From: Richard Castro-Parker
Sent: 30 April 2019 10:29
To: Lynnyrd Wolfe
Subject: FW: FP/274/18/PL - 10 Felpham gardens.
Attachments: Prop FF Plan Unit 2 Rev A.PDF; Prop Elevations Unit 2 Rev B.PDF

From: Juan Baeza
Sent: 25 April 2019 15:07
To: 'Tim Rodway | Rodway Planning'
Cc: Richard Castro-Parker
Subject: RE: FP/274/18/PL - 10 Felpham gardens.

From: Tim Rodway | Rodway Planning
Sent: 24 April 2019 17:06
To: Richard Castro-Parker
Cc: Juan Baeza
Subject: RE: FP/274/18/PL - 10 Felpham gardens.

From: Richard Castro-Parke [REDACTED]
Sent: 11 April 2019 16:13
To: [REDACTED]
Cc: [REDACTED]
Subject: FP/274/18/PL - 10 Felpham gardens.

PROPOSED ELEVATIONS
UNIT 2

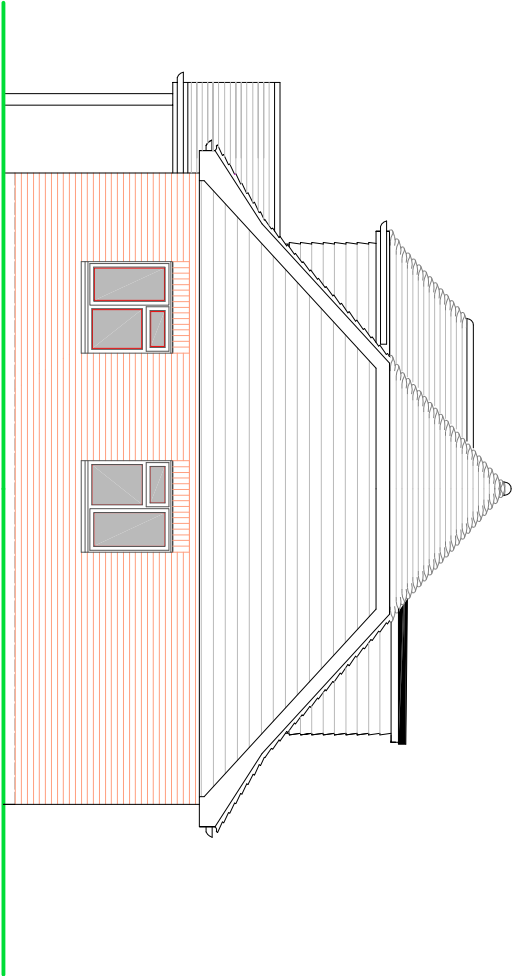
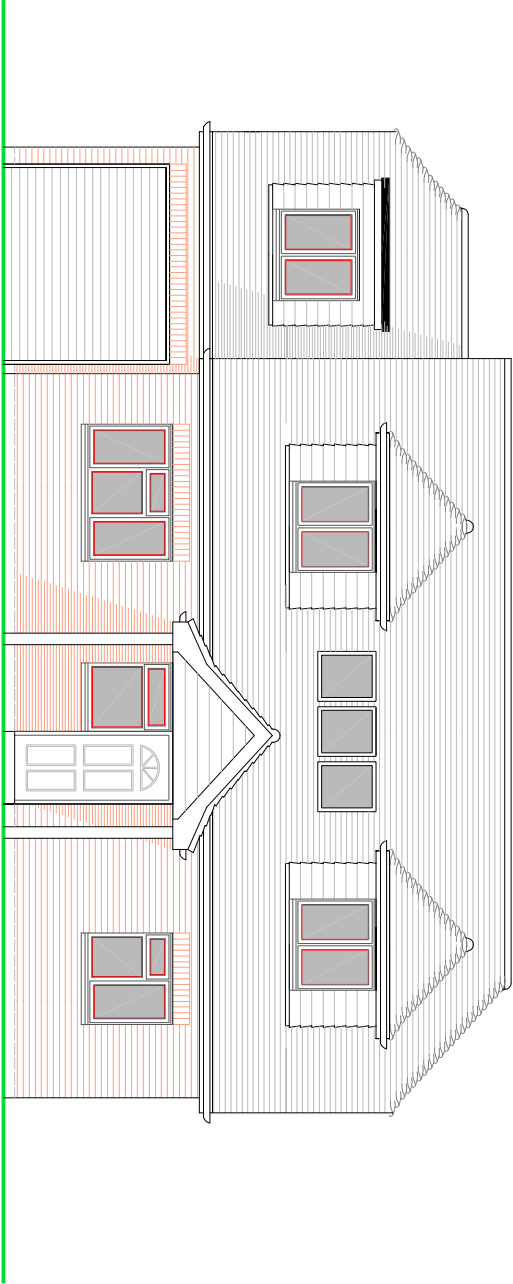
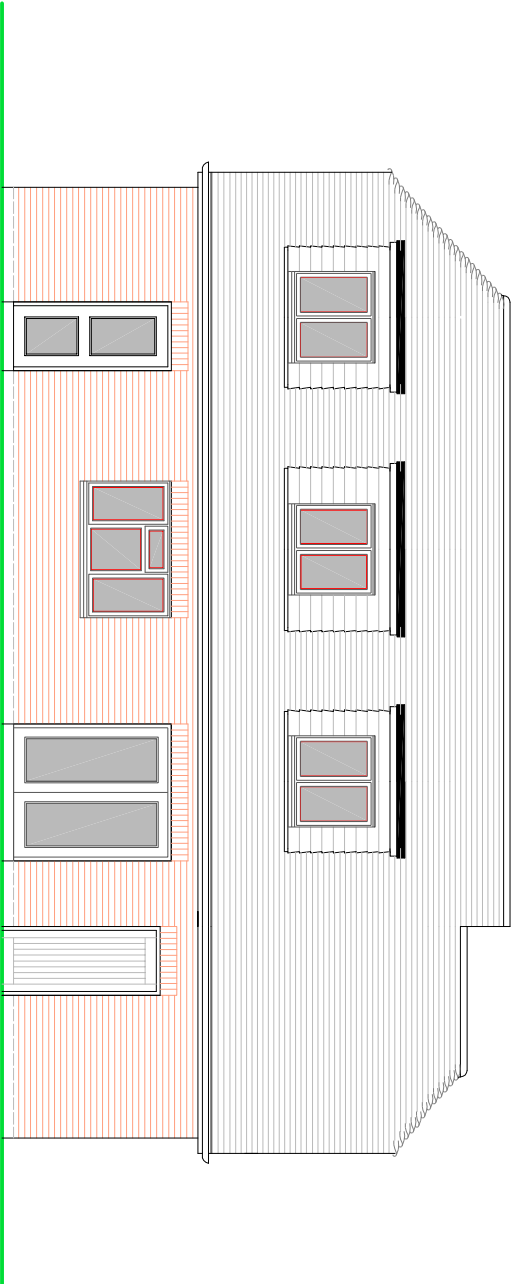
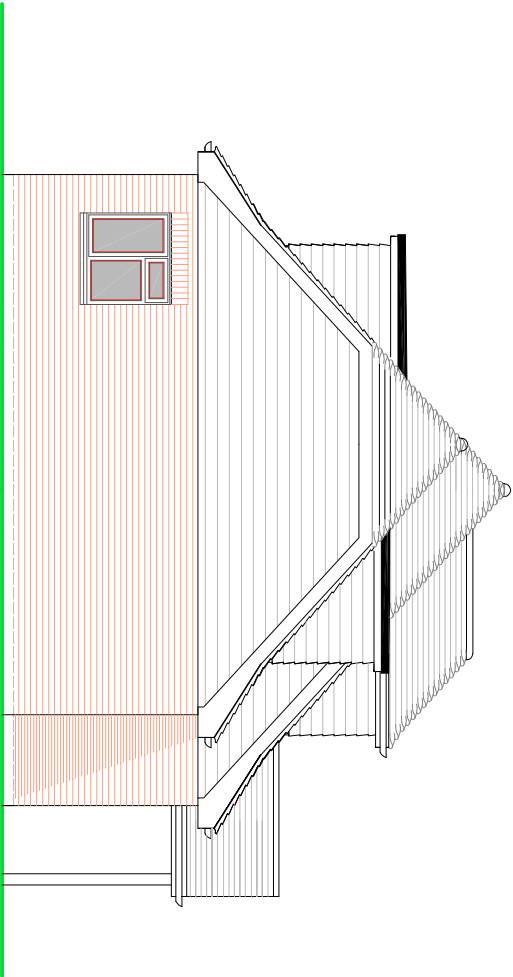
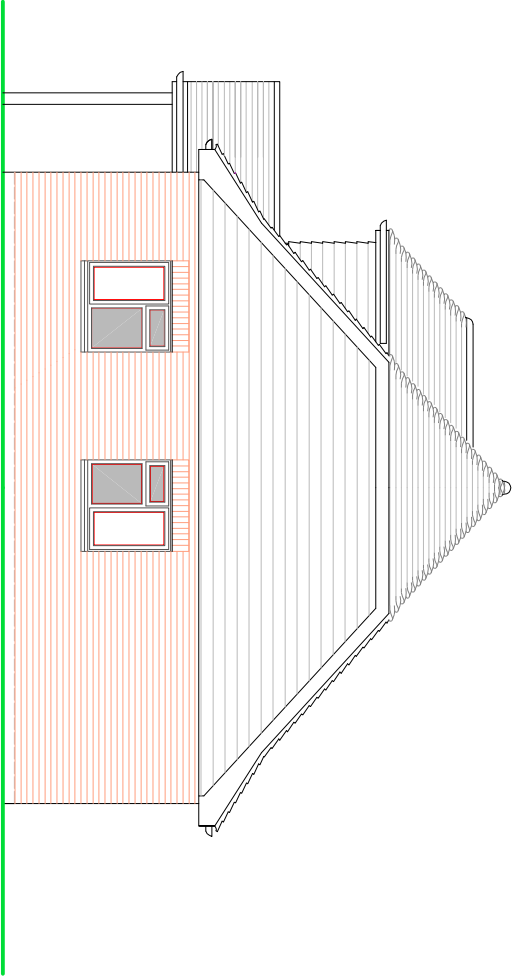
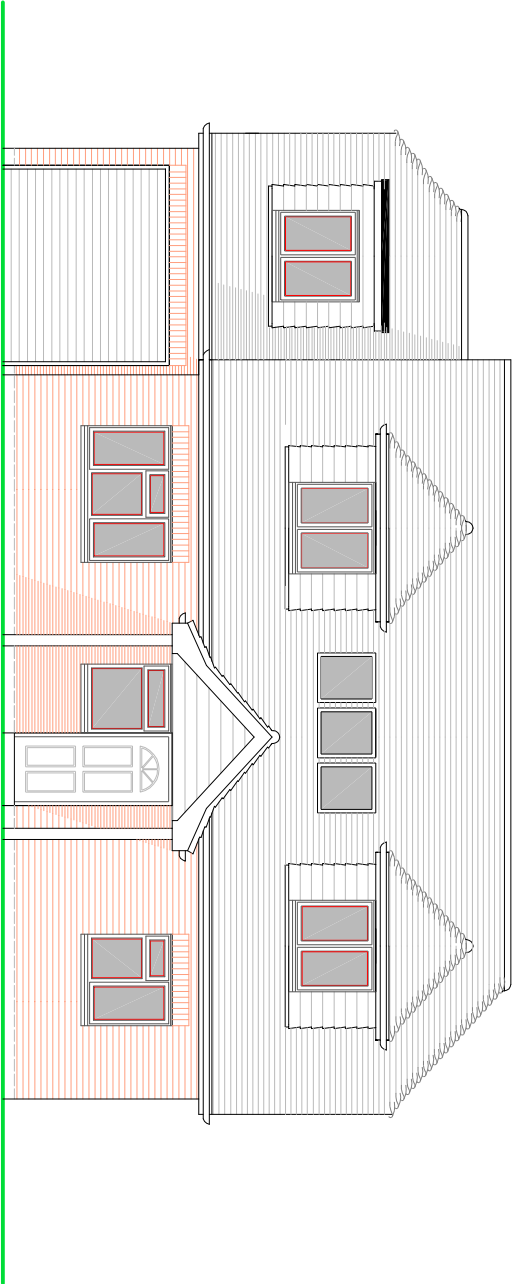
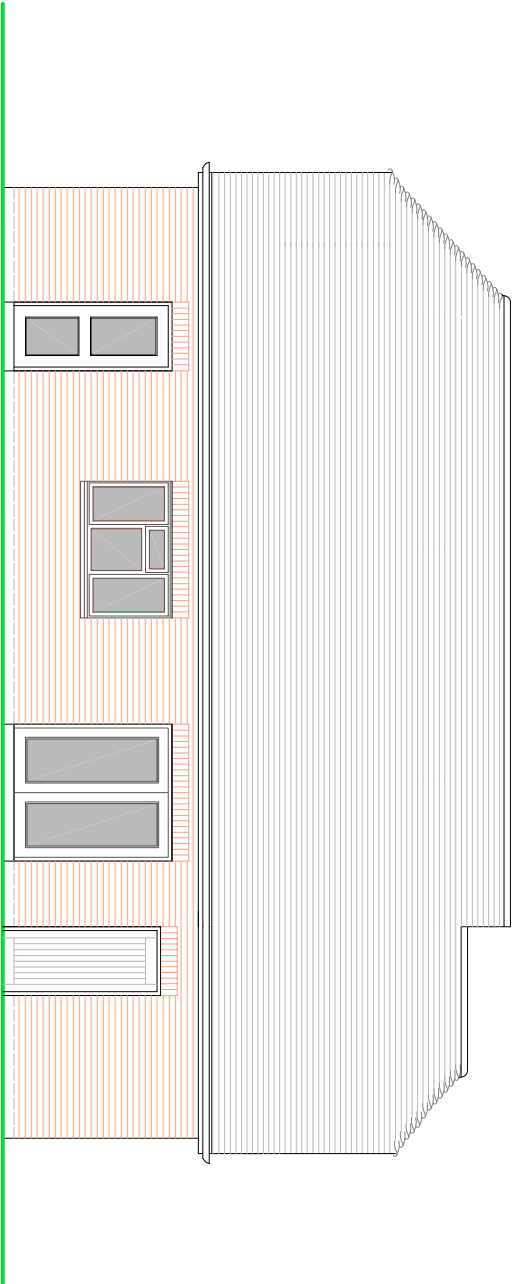
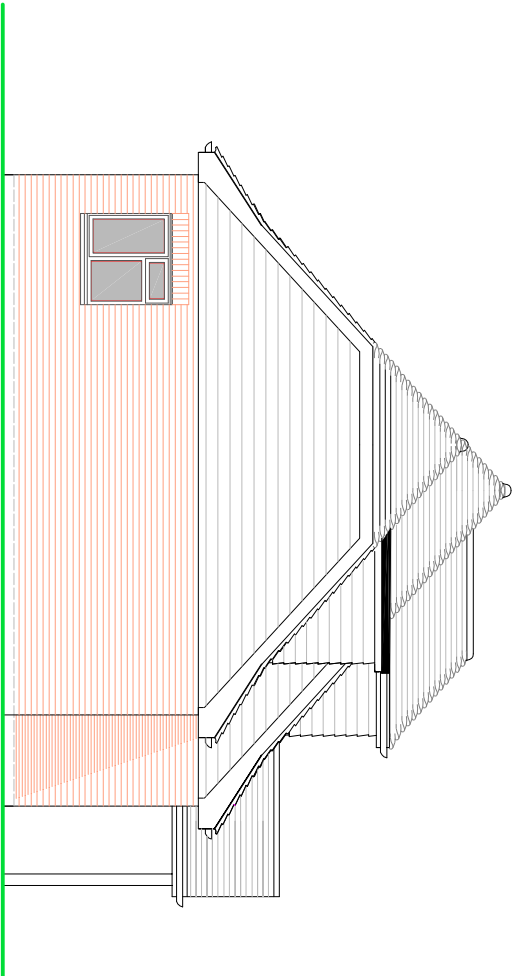
We understand that the principle issue is the potential for overlooking from the rear dwelling that is proposed (Unit 2). Consequently we have deleted the rear dormers entirely, and this property would now have no north facing windows at first floor level. The first floor accommodation would be served solely by the south facing windows. The consequence of deleting the rear dormers also means that the bulk and scale of Unit 2 has been reduced.

I am emailing regarding 10 Felpham Gardens, Felpham. I apologise for the delay in determining this application. I have discussed this application with both my manager and the Head of planning. It is considered that the proposals would lead to a detrimental impact on the residential amenity of the occupiers of adjoining properties. It is considered that the dormer windows facing north in the rear elevation of unit 2 are close to the common boundary of the adjoining property and would lead to detrimental overlooking. These windows could be obscured but it would create the perception of overlooking and result in a building with an overbearing impact on the on the rear garden of the adjoining property.

The revised gross internal floor area of Unit 2 is now 144 sqm (comprising 69 sqm at ground floor, 20 sqm garage space, and 55 sqm at first floor).

We consider that the attached plans that show revisions to Unit 2 would overcome the concerns that have been raised, in that it would create satisfactory living conditions for neighbouring occupiers. Given these alterations to the proposed drawings, we now suggest that the application can be recommended for approval.
